**Consultation Response from KC,
Strategic Housing**

2024/91242 Land north east of, Shepley Road, Stocks Moor, Huddersfield, HD4 6XW

**Erection of residential development (up to 50 dwellings) with associated access, parking,
public open space, landscaping and infrastructure**

Responding Ref: SH/24/91242

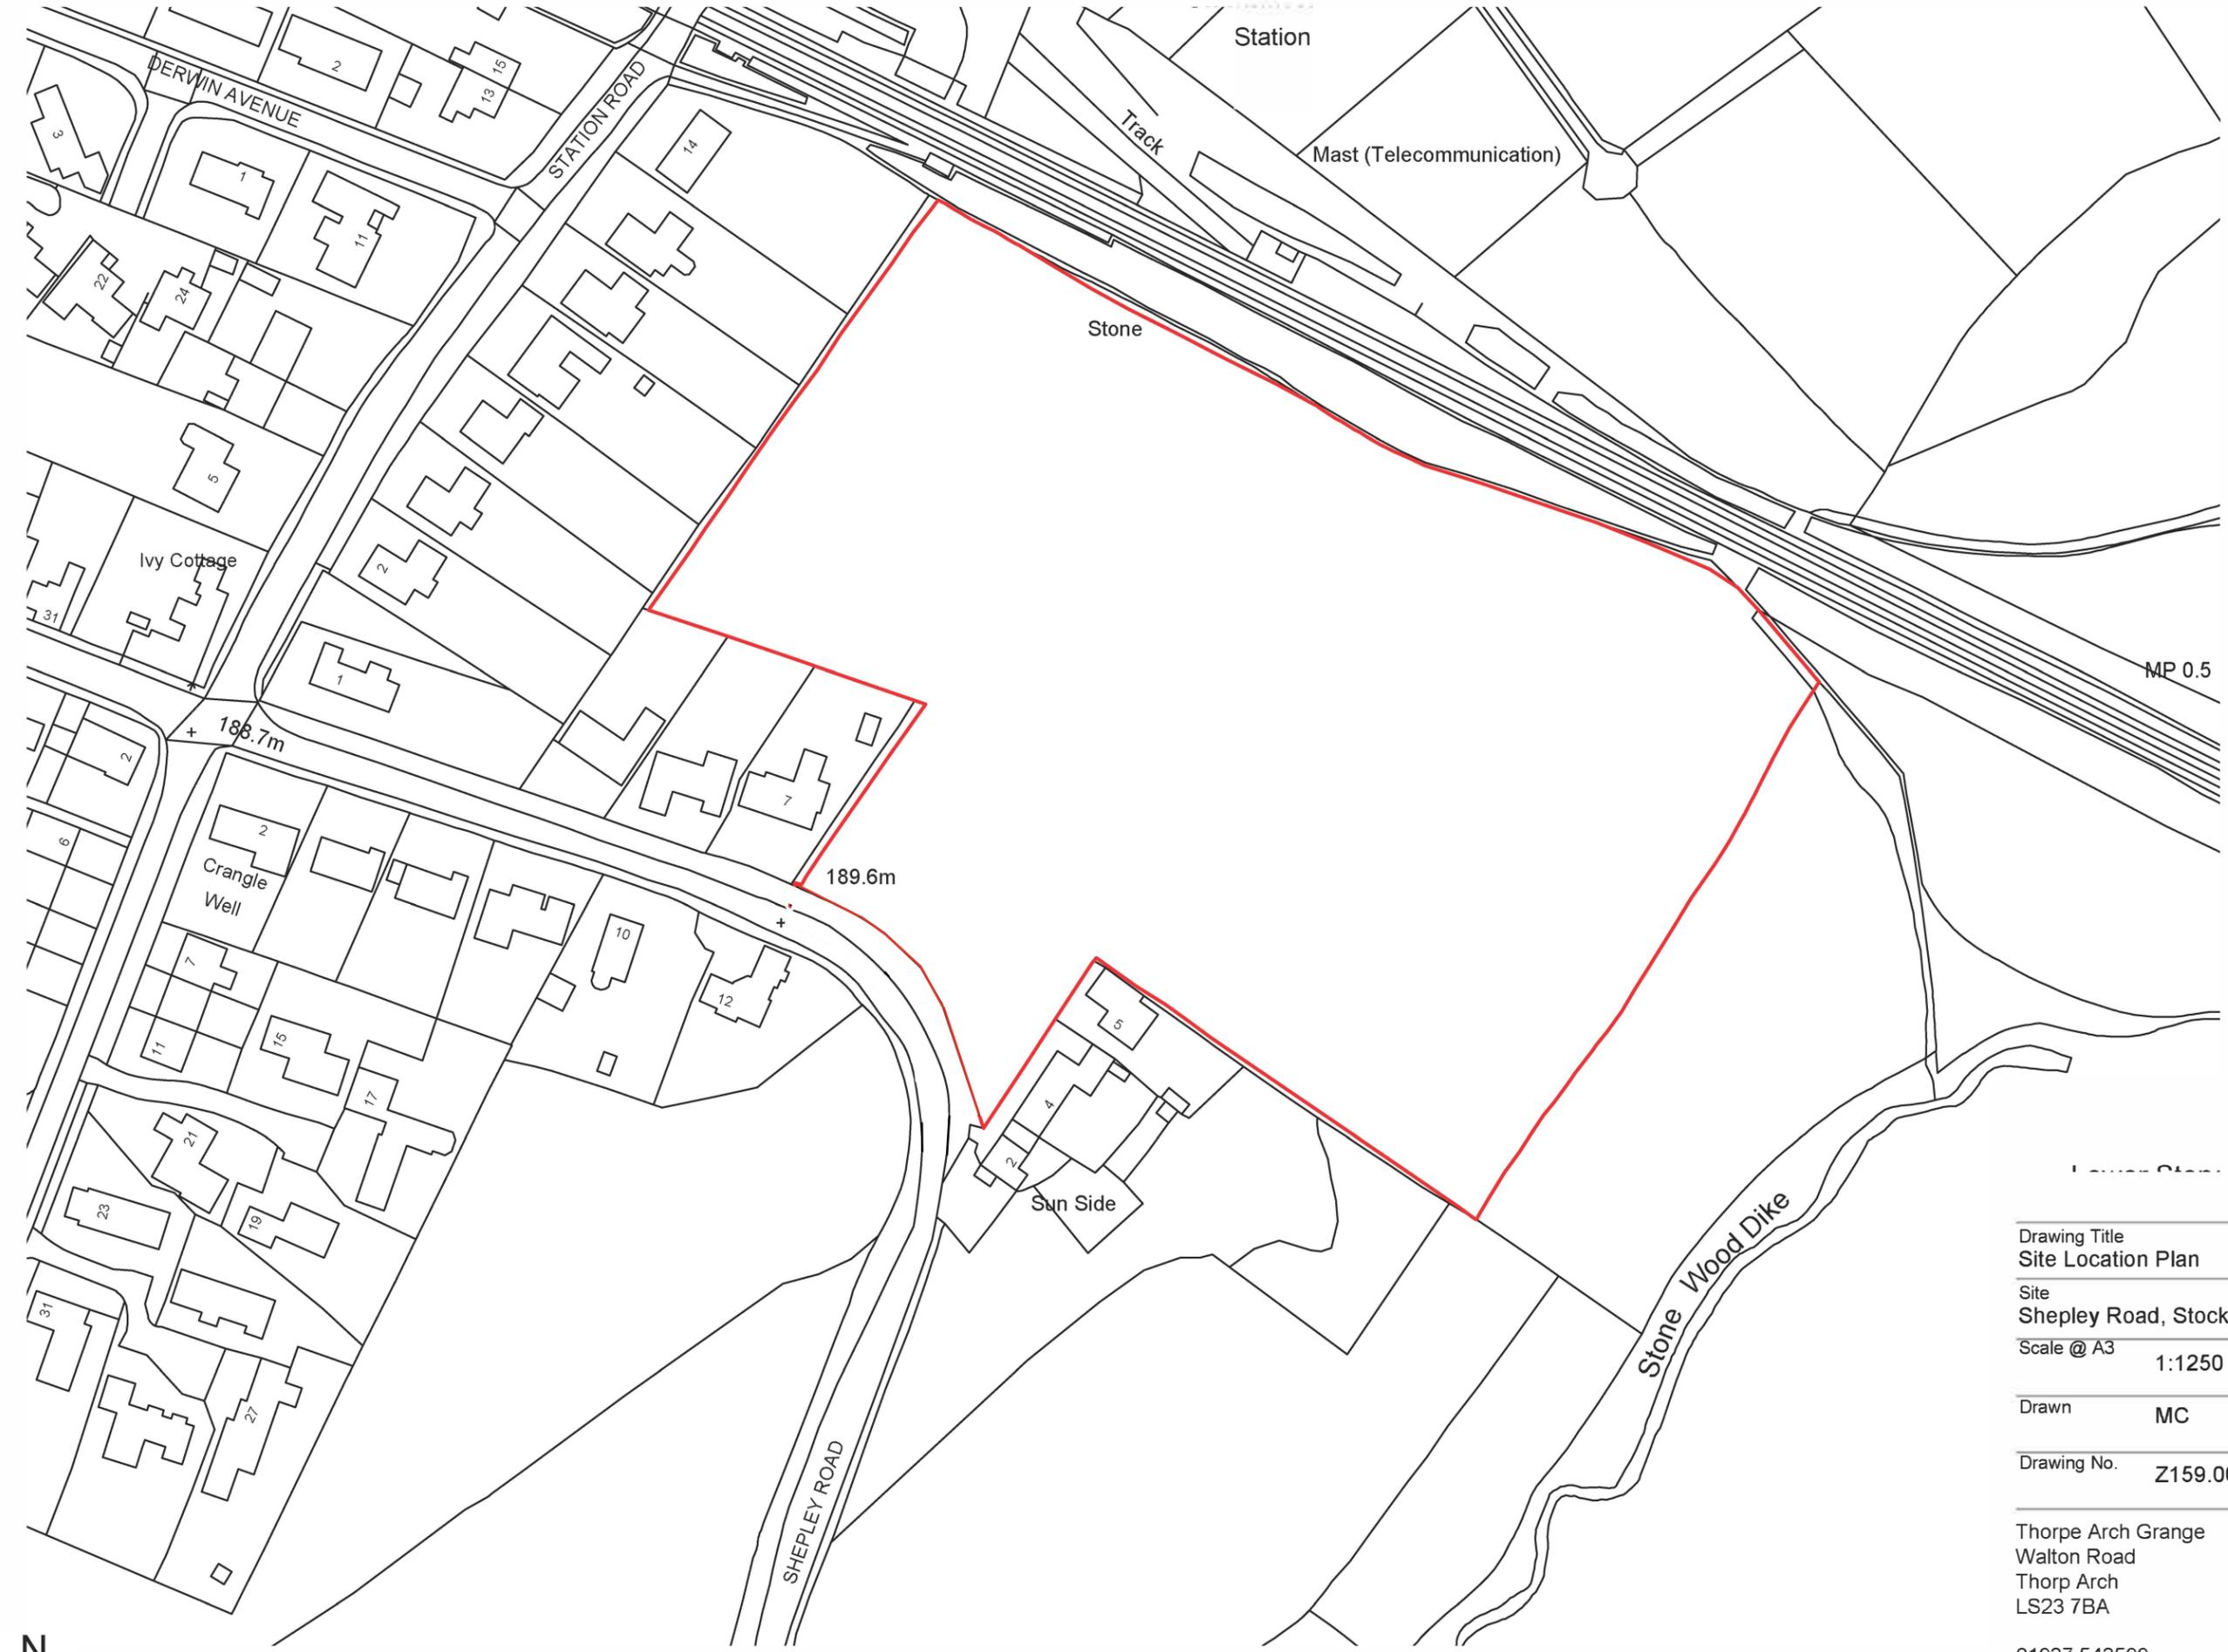
The proposed layout shows that the affordable homes are not distributed evenly throughout the development, as they are all grouped together at the back of the development. In addition to this it is noted that some aspects of the design brief indicate that the Affordable dwellings have specific differences to the market dwellings (eg boundary fencing). Therefore, Strategic Housing does not support the current proposal.
